CITY OF ALBUQUERQUE

November 26, 2018

Re: 2100 Osuna NE
Traffic Circulation Layout
Engineer's Stamp **02-08-18** (E16-D001)

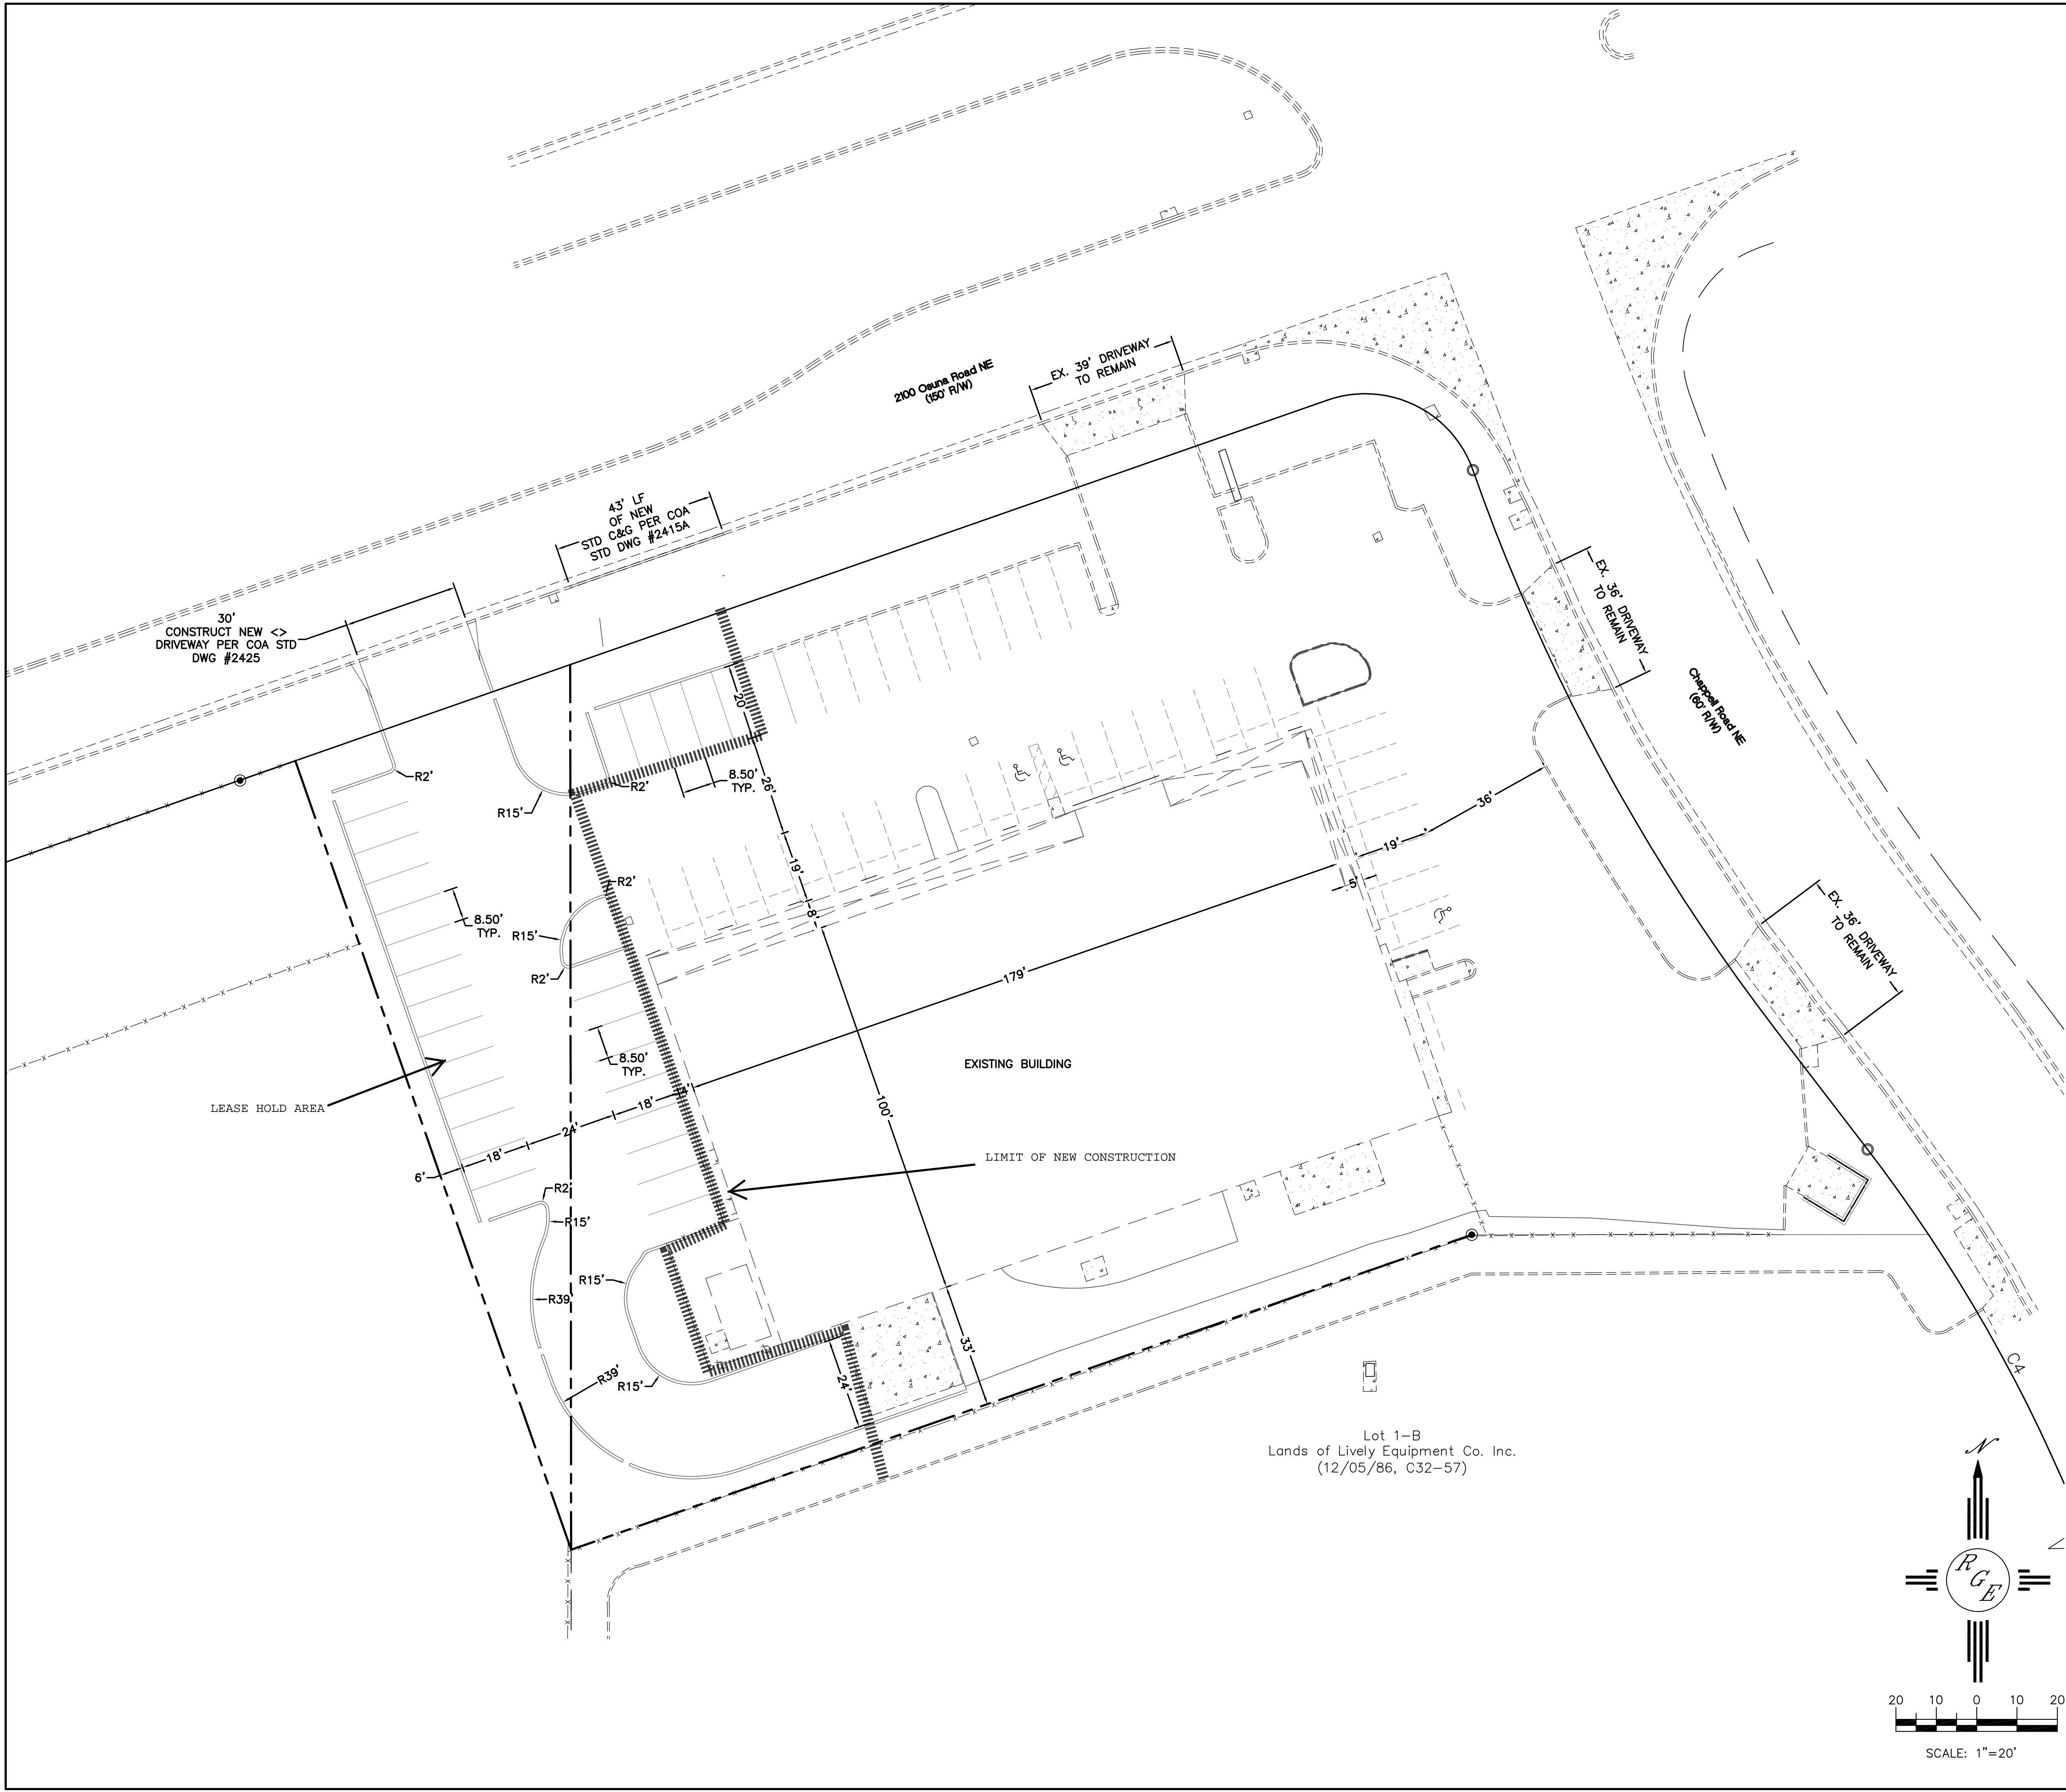
1. Please include a copy of your cross access easements/agreements and shared parking agreement.
2. Parking spaces cannot cross over lot lines.
